Memorandum
Department of Planning and Development
Historic Preservation Office

To: Chair Morrisette and Members of the Planning Board
From: Deborah Andrews, Historic Preservation Program Manager
Date: October 4, 2012
Re: Proposed Hotel at Northeast Corner of Fore and Union Streets -
Historic Preservation Board's Analysis of Historic Context,
Comments on Preliminary Design Proposal

Drawing Title
**EAST AND WEST
 ELEVATIONS**

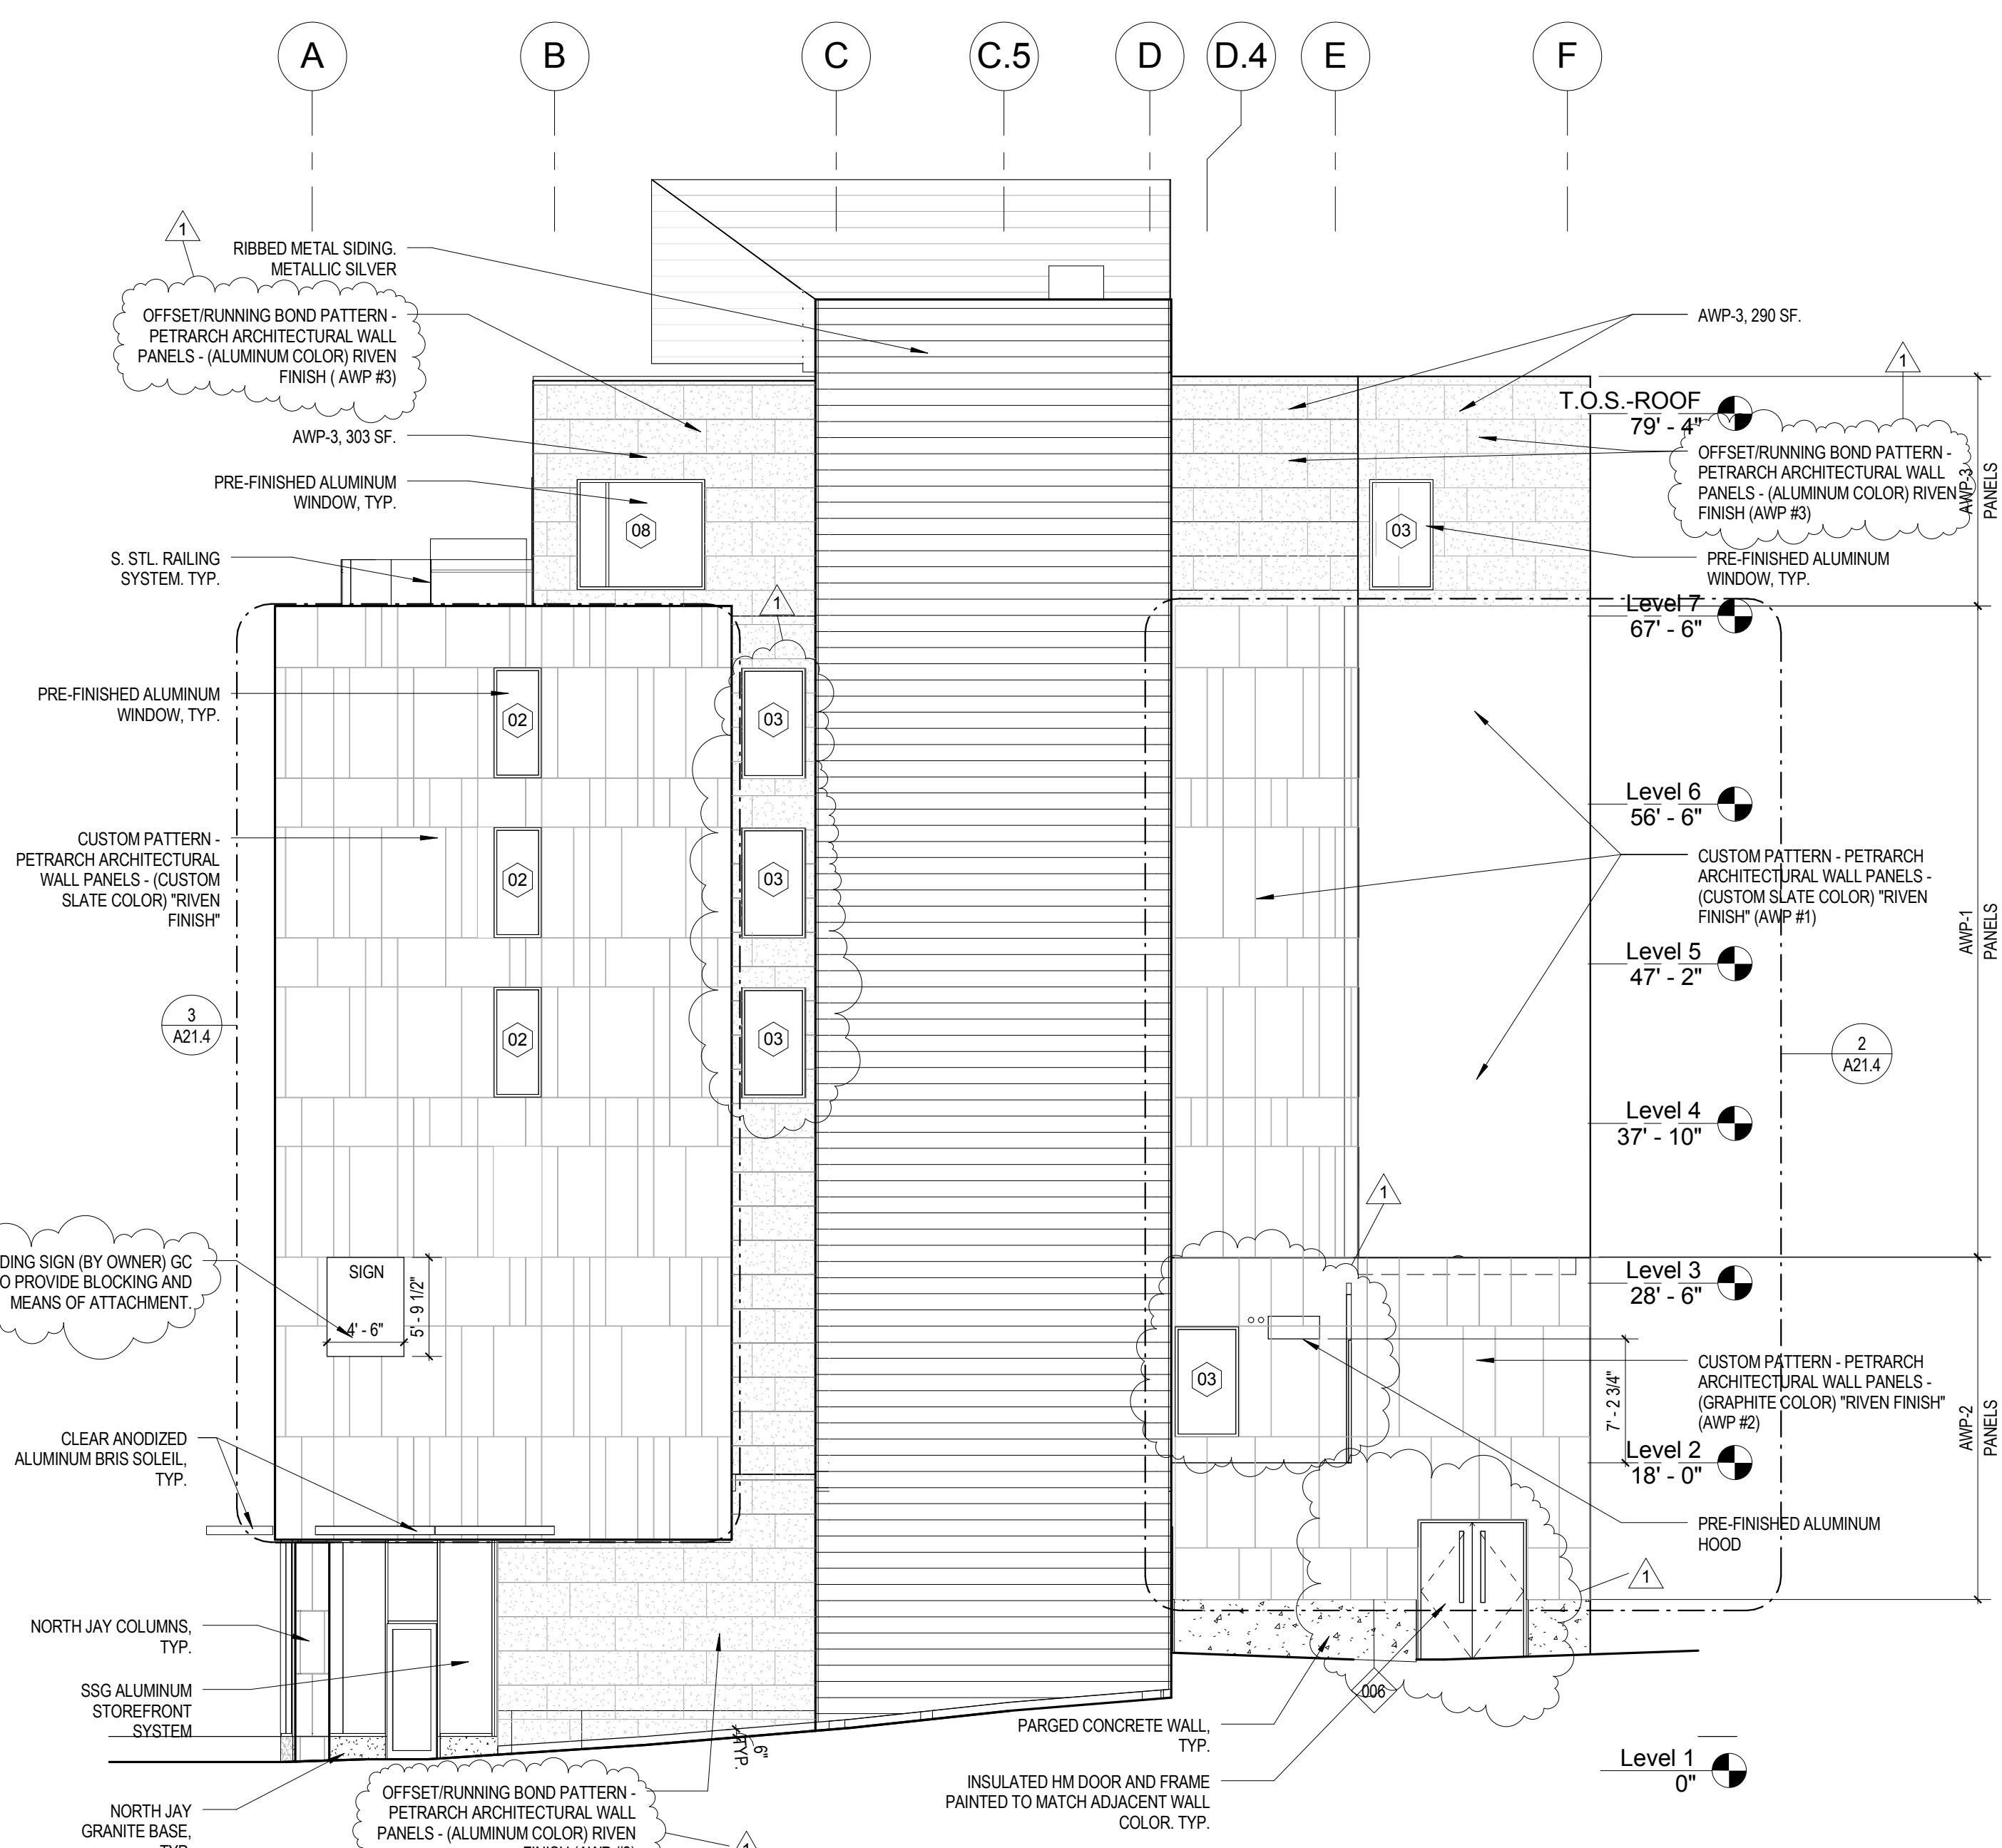
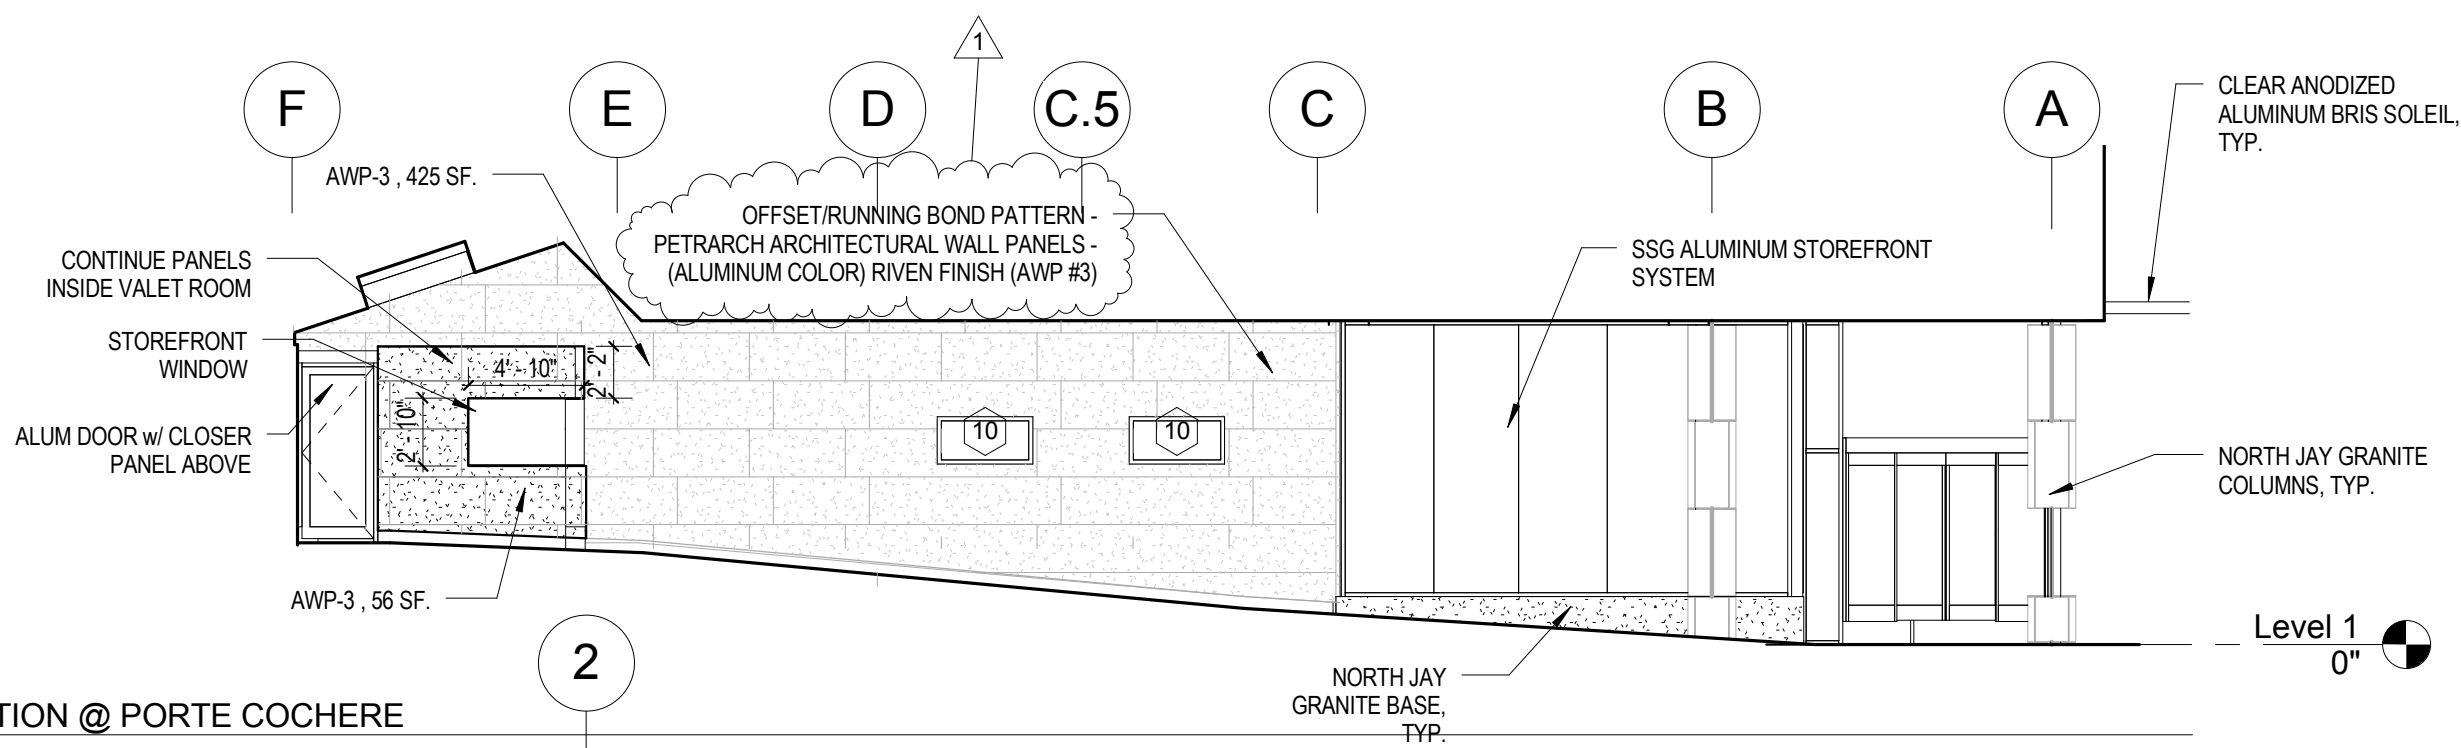
- Board members stressed the importance of the eastern corner of the hotel, particularly at the ground floor level, where the corner of the hotel will project beyond the face of the garage next door. Glazing this corner and providing an entrance in this location was endorsed. Board members also noted that the sunscreen on this facade will extend beyond the face the adjacent garage. This design detail should be given careful consideration.
